Mrs Sarah Dand

Conversion of buildings to create nine dwellings (Use Class C3) and associated works, including demolition of existing extensions, alterations to exterior and formation of first floor.

St Barnabas Church, Old Mill Lane, Barnsley, S71 1PN

Drawing title  
Proposed Elevations

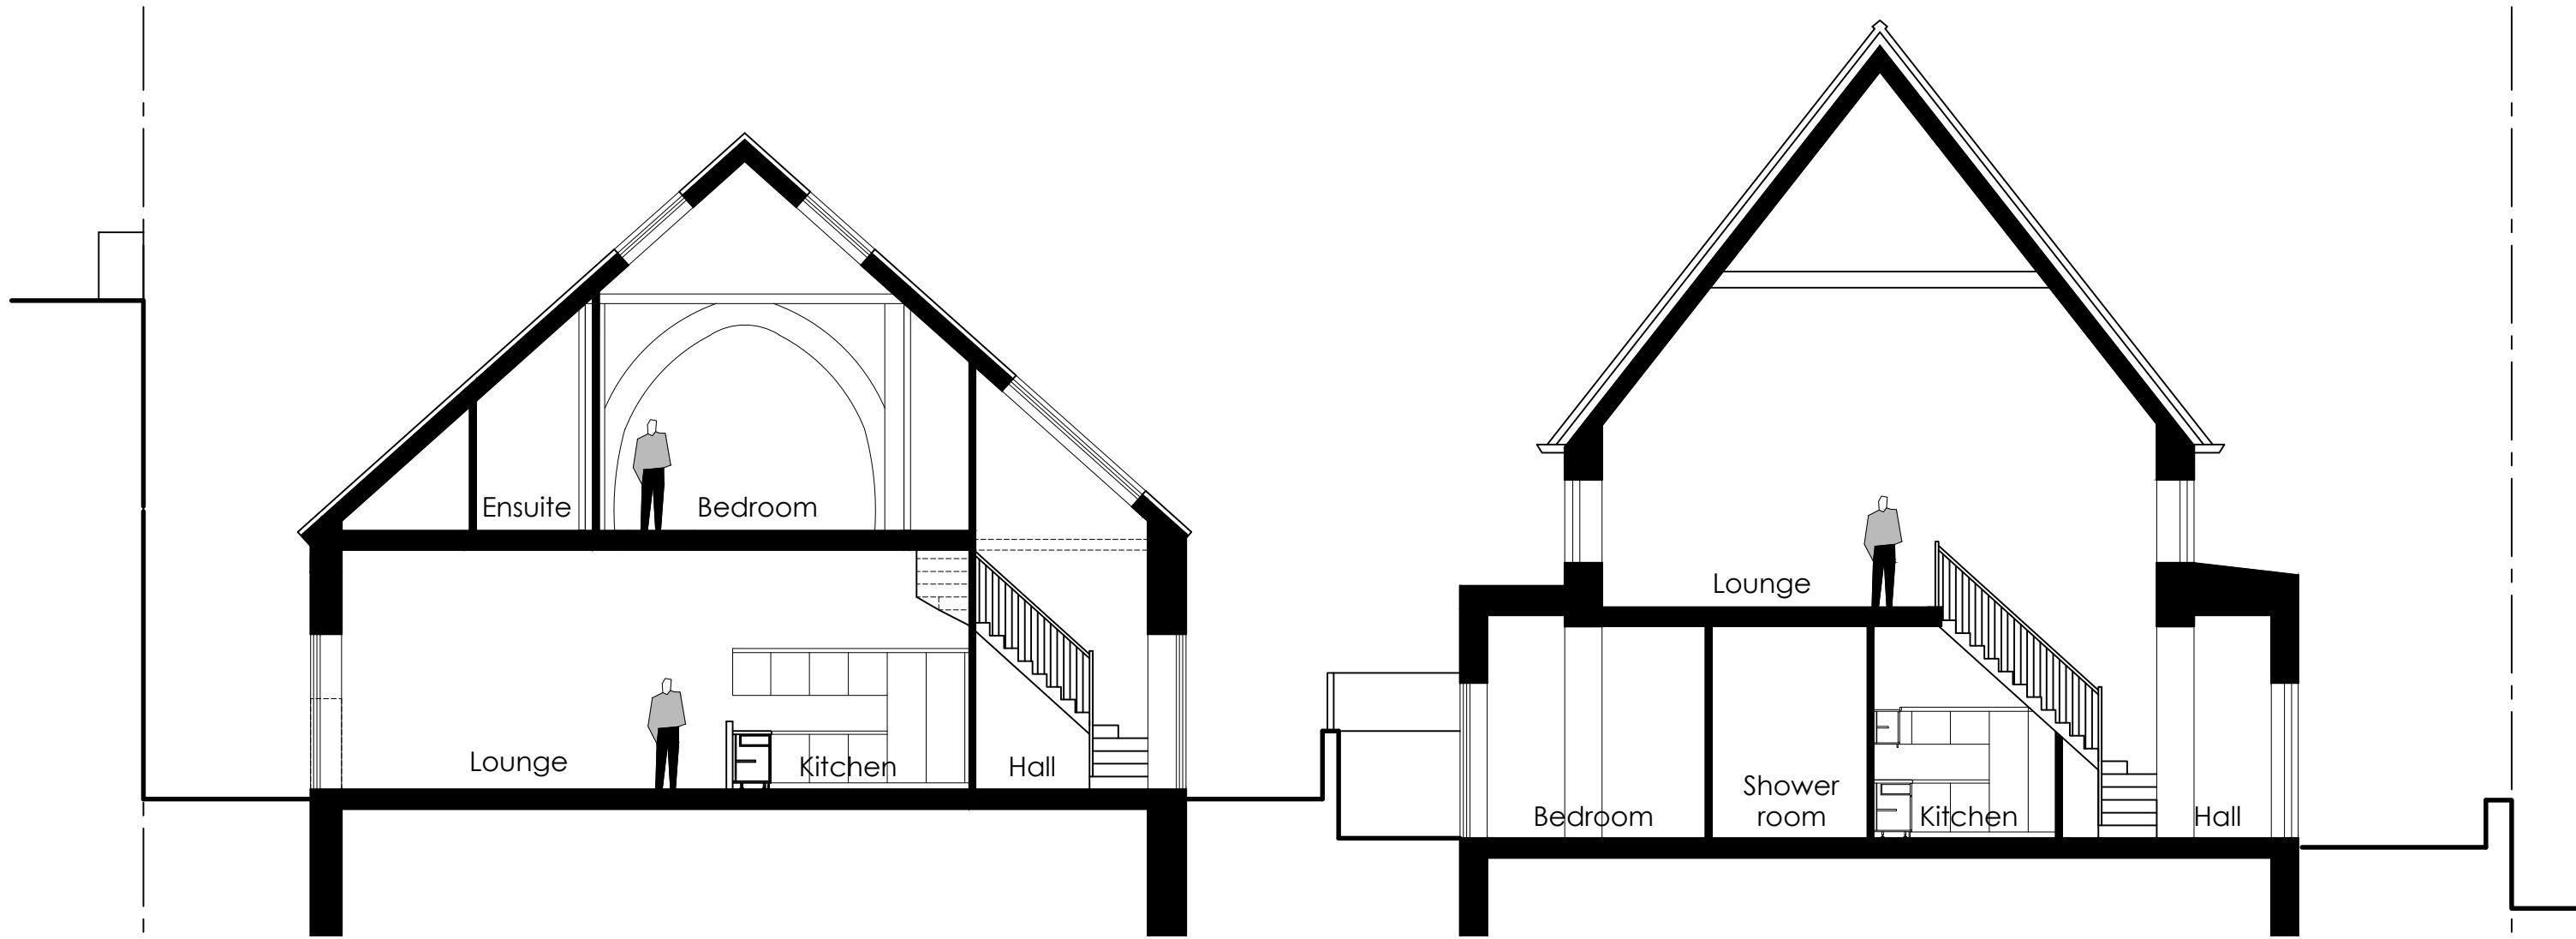
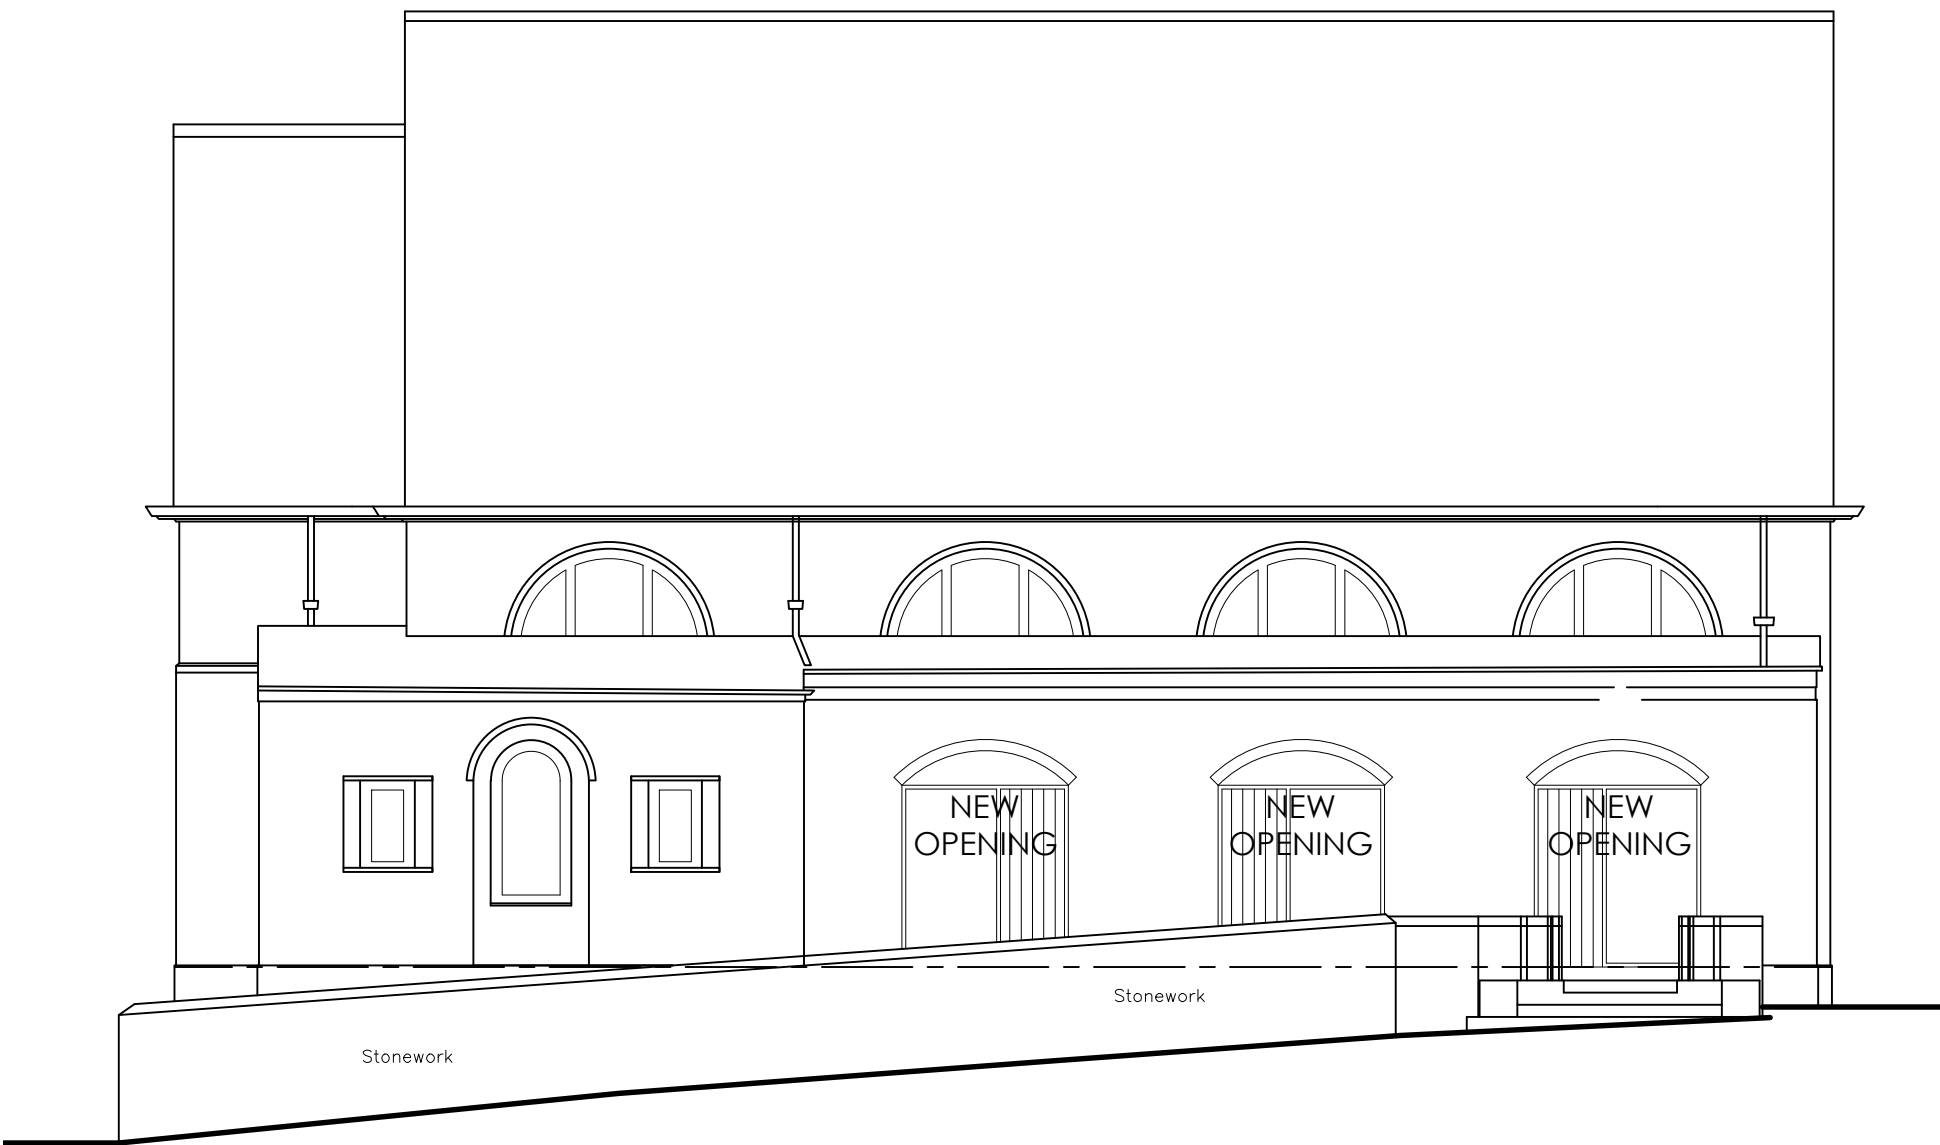
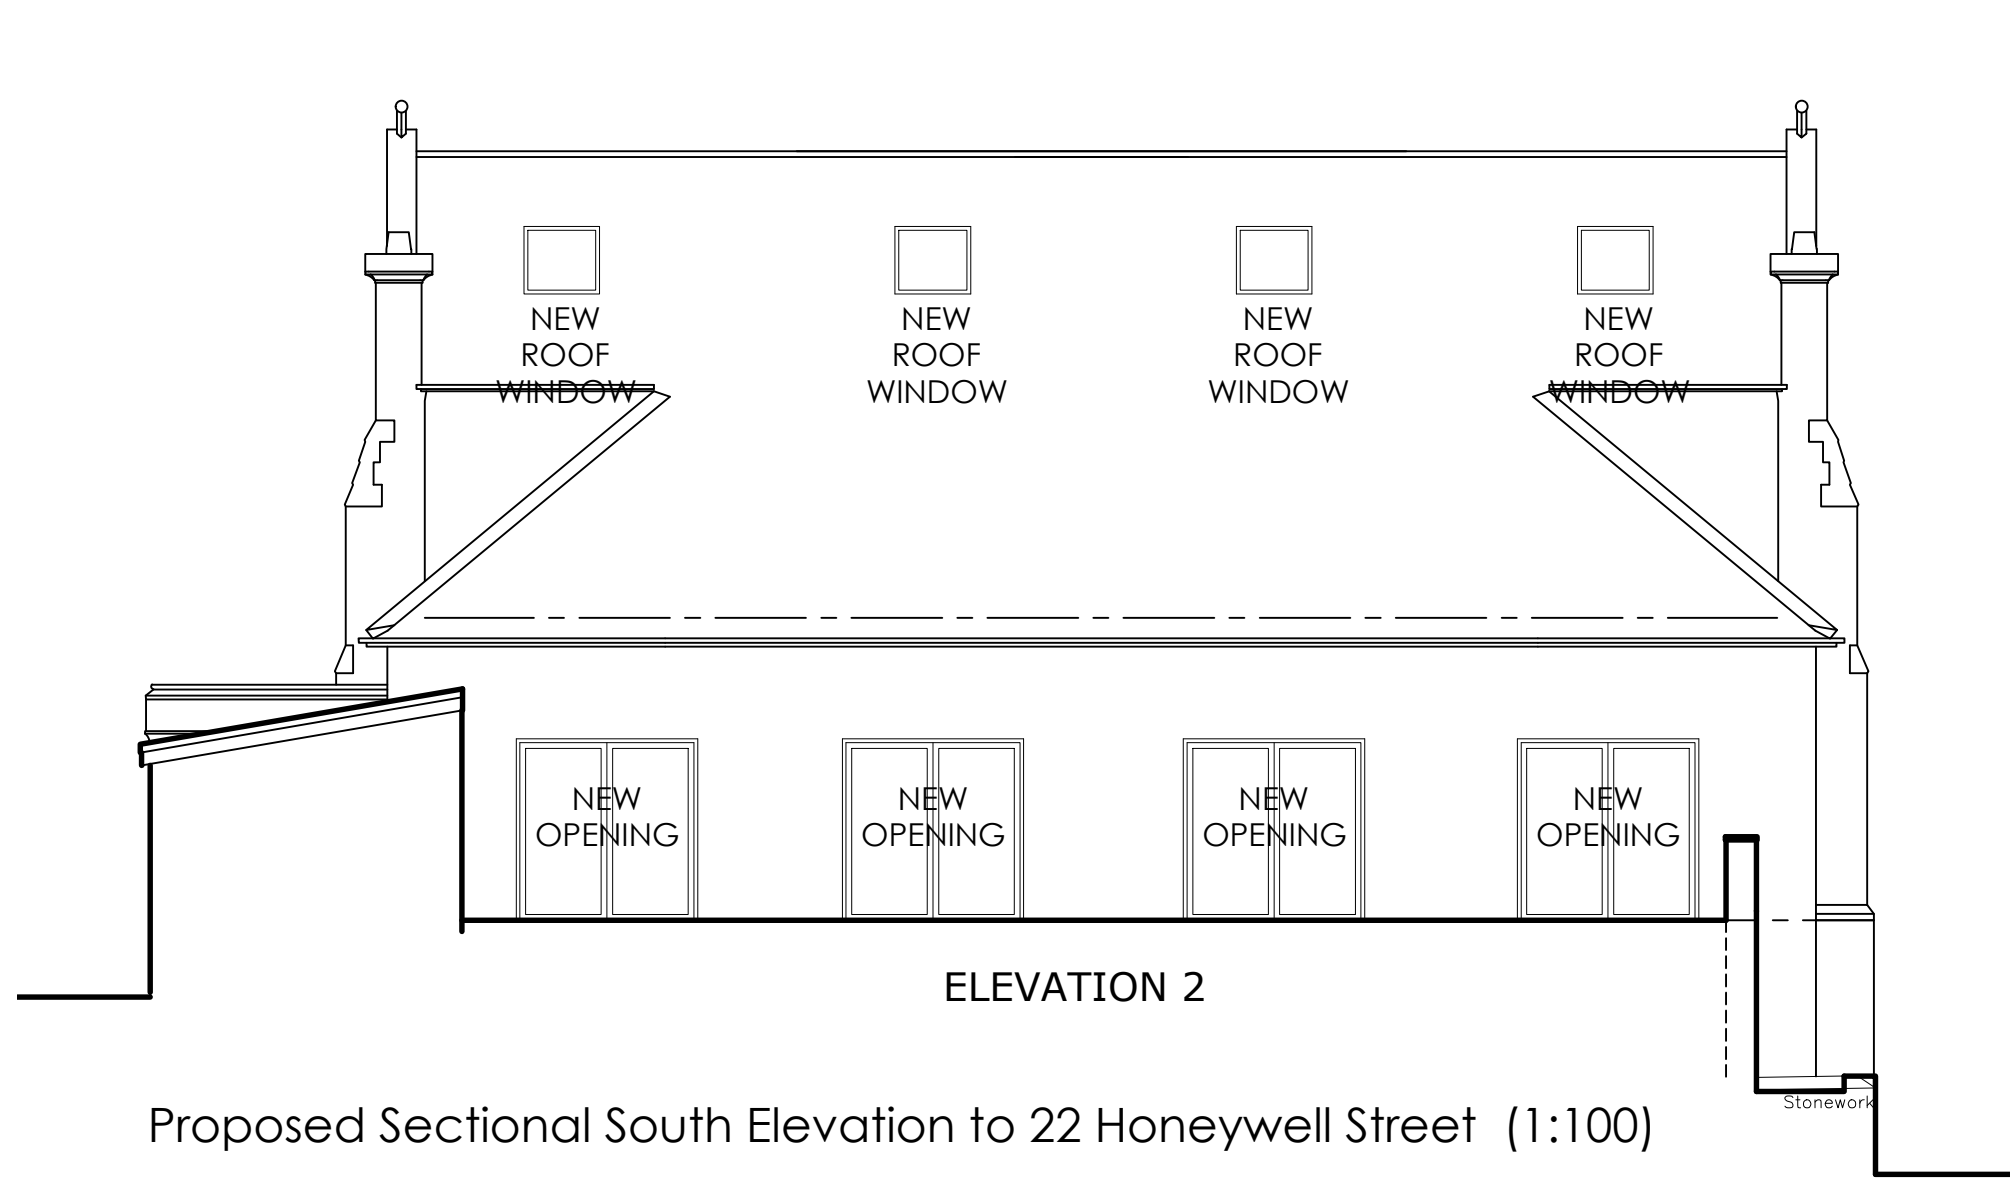
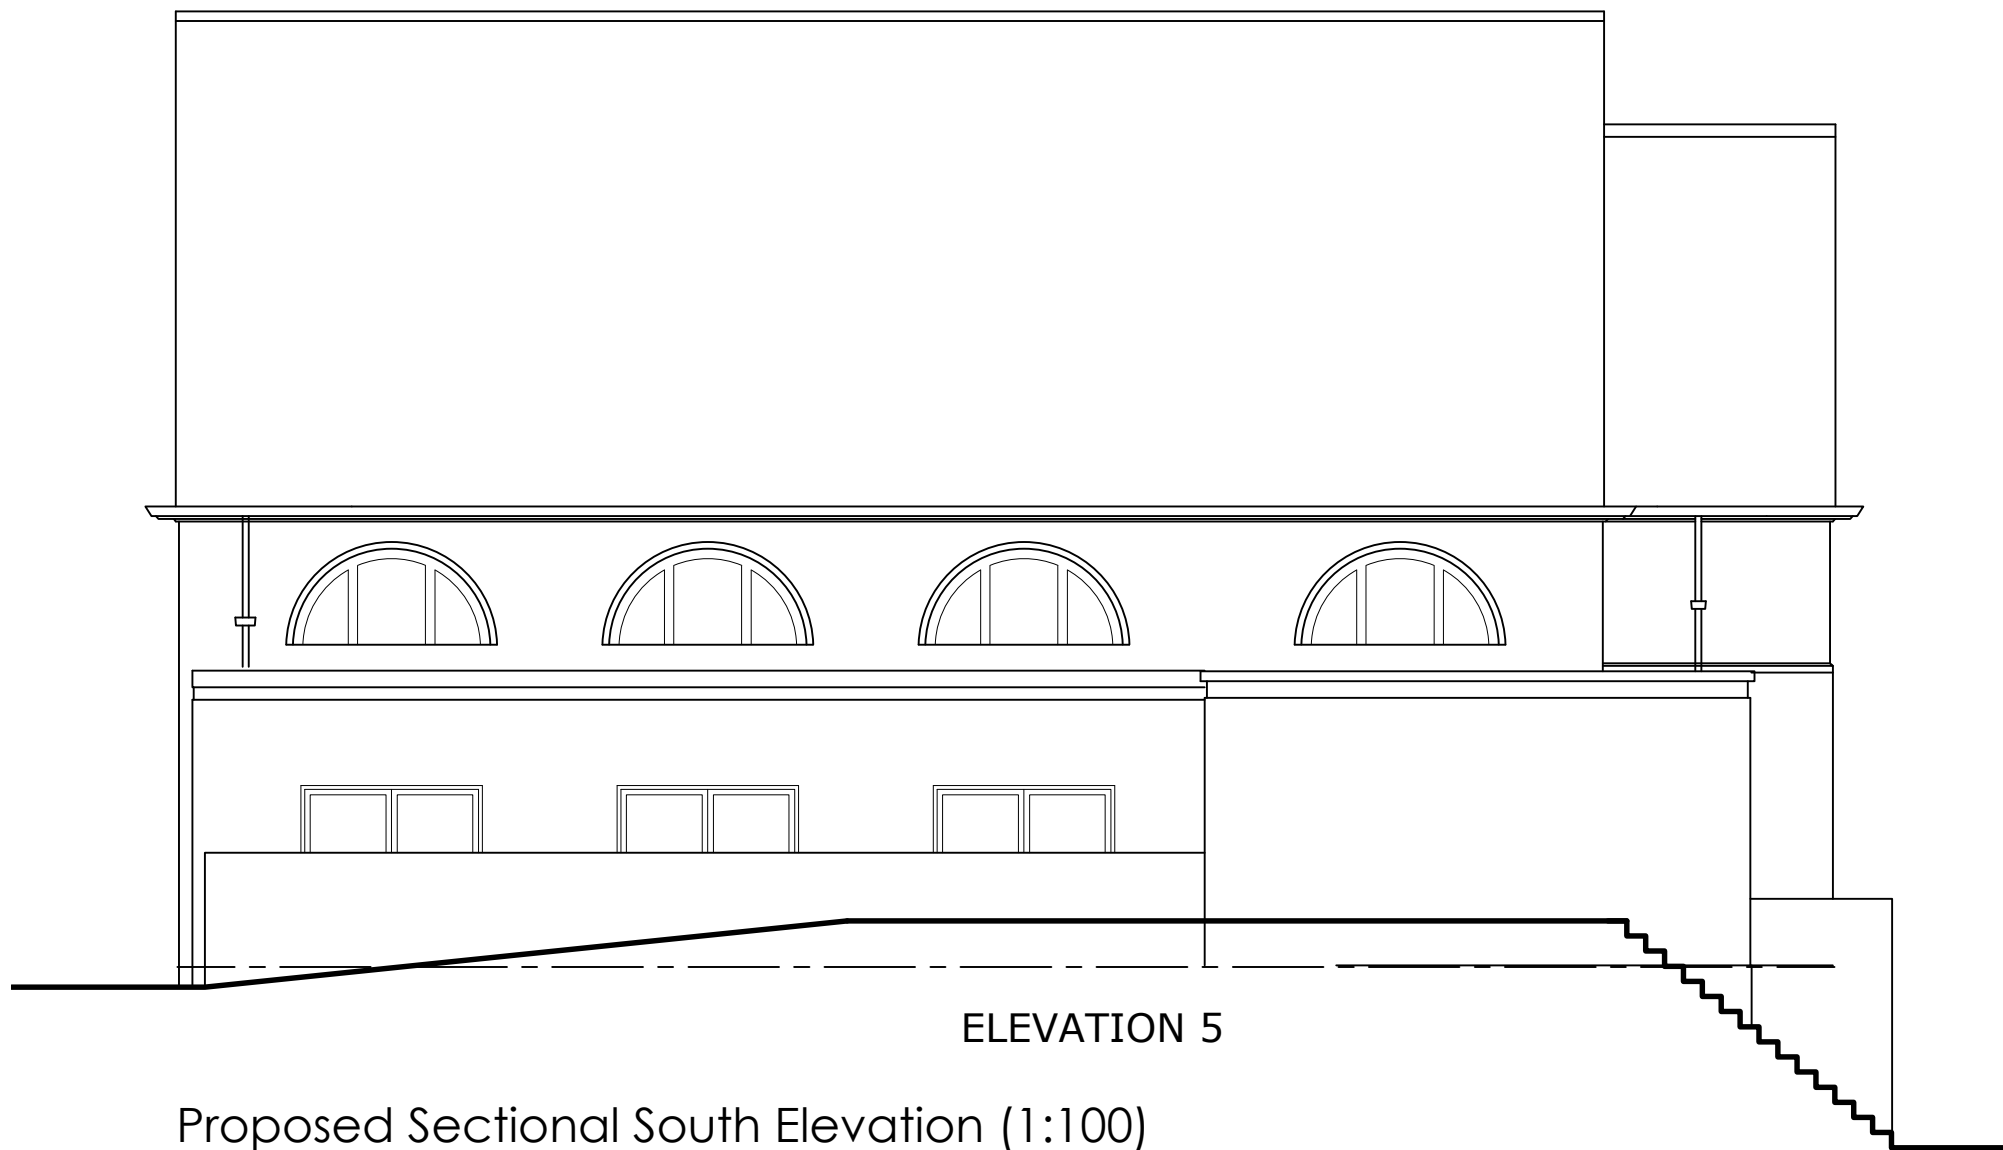
As described above, the majority of the new window openings are at ground floor and roof level and therefore would not cause direct overlooking of neighbouring properties. However, the LPA did raise concerns that overlooking from Flat 9's first floor bedroom could occur upon residents of Nos. 51 and 53 Bridge Street. This is due to the separation distance between the rear elevation of those properties and the western elevation of church being only 18.1m, thus below the SPD requirement. Whilst, the existing large trees and small garden outbuildings do provide some screening, the proposal has been amended to ensure that the existing large gable end windows are obscure glazed to prevent overlooking.

Typically, main habitable room windows (such as bedrooms) are not obscure glazed to ensure adequate levels of natural light. However, given that the bedroom will also be served by the proposed rooflights, the installation of obscure glazing is considered to be acceptable. To protect amenity further, the eastern facing gable windows (which would serve Flat 6's bedroom) will also be obscure glazed for the same reasons. The proposed plans have been updated to reflect this and a condition attached.
